Project #: 1006003 Application #: 14DRB-70344  
 Project Name: MESA DEL SOL INNOVATION PARK  
 Applicant: BOHANNAN HUSTON INC Phone: \_\_\_\_\_

**CITY OF ALBUQUERQUE  
PLANNING DEPARTMENT  
October 8, 2014  
DRB Comments**

**RE: Tracts 23A & 23-B, Mesa del Sol**

**PLAT OF
TRACTS 23-A-1 & 23-B-1
MESA DEL SOL
INNOVATION PARK**
(A REPLAT OF TRACTS 23-A & 23-B MESA DEL SOL
INNOVATION PARK)
ALBUQUERQUE, BERNALILLO COUNTY, NEW MEXICO
SEPTEMBER 2014

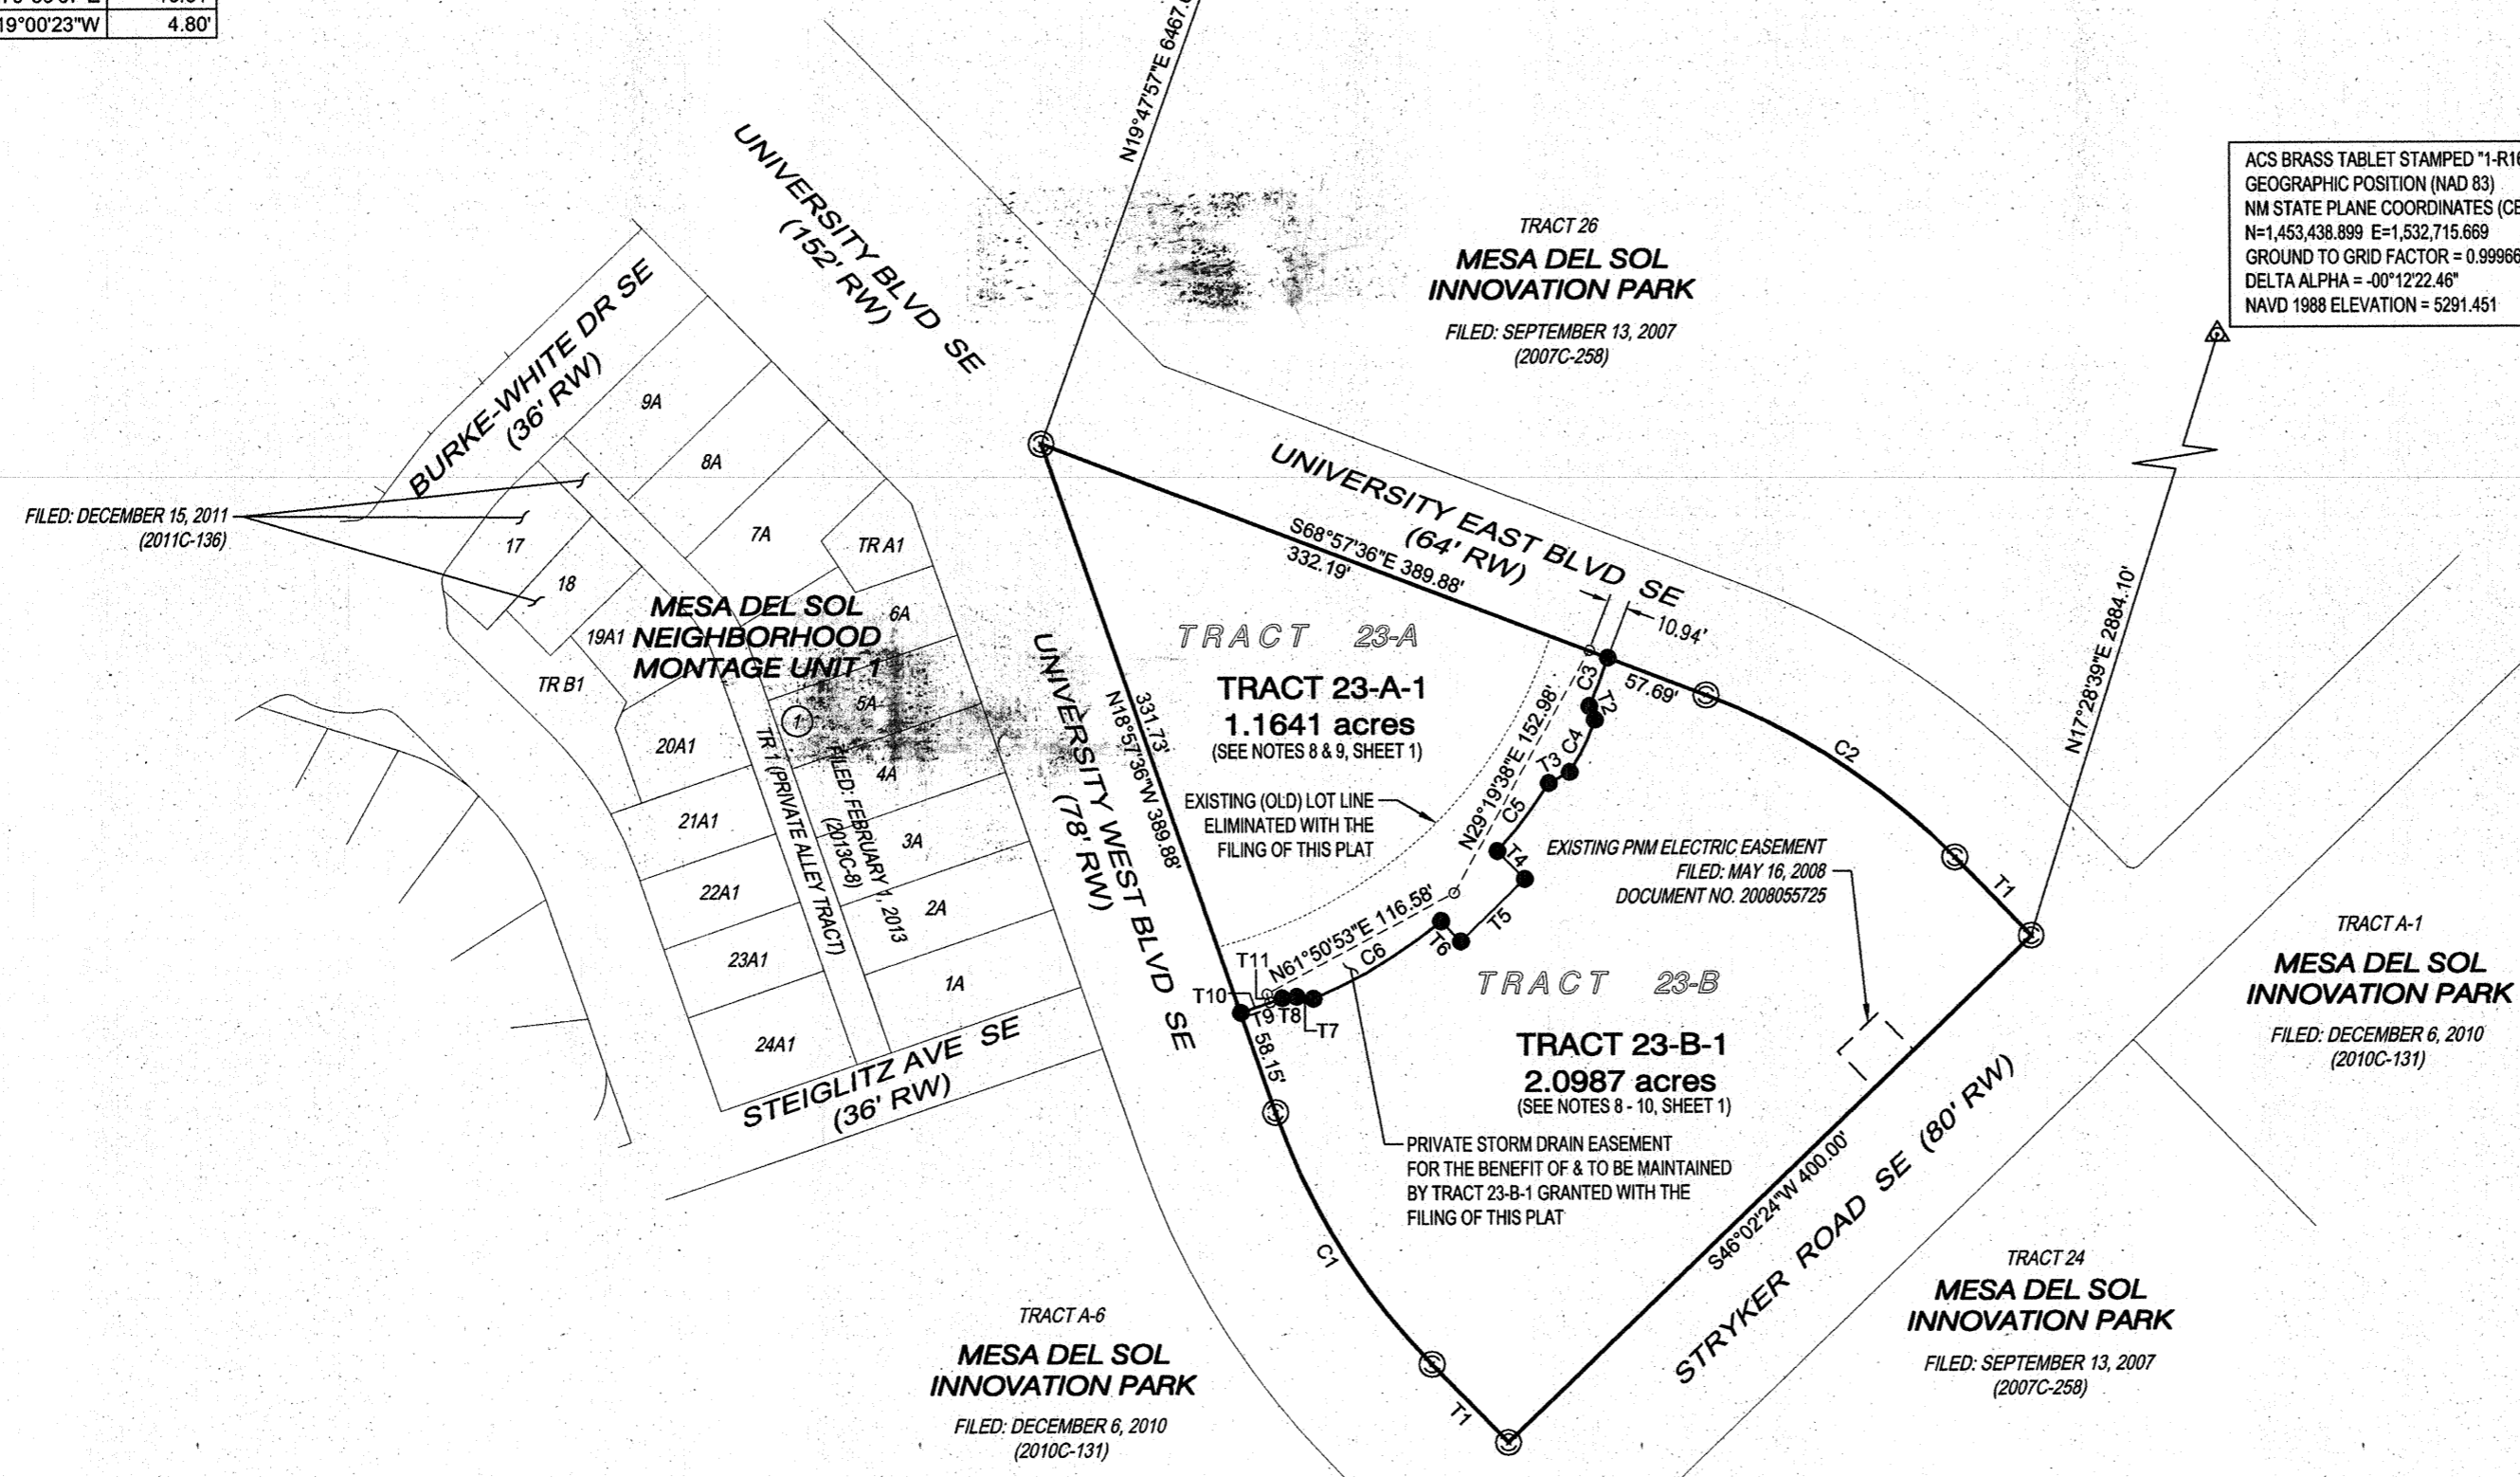
The previously approved plat from last year must be formally withdrawn; the Subdivision Ordinance requires that a plat be filed by October 30 or the previously approved vacations will be void. Irrigation accounts/ setup need to be clarified; based on existing landscaping, it appears some tree wells will be on a different lot than the water supply which will require an irrigation agreement.
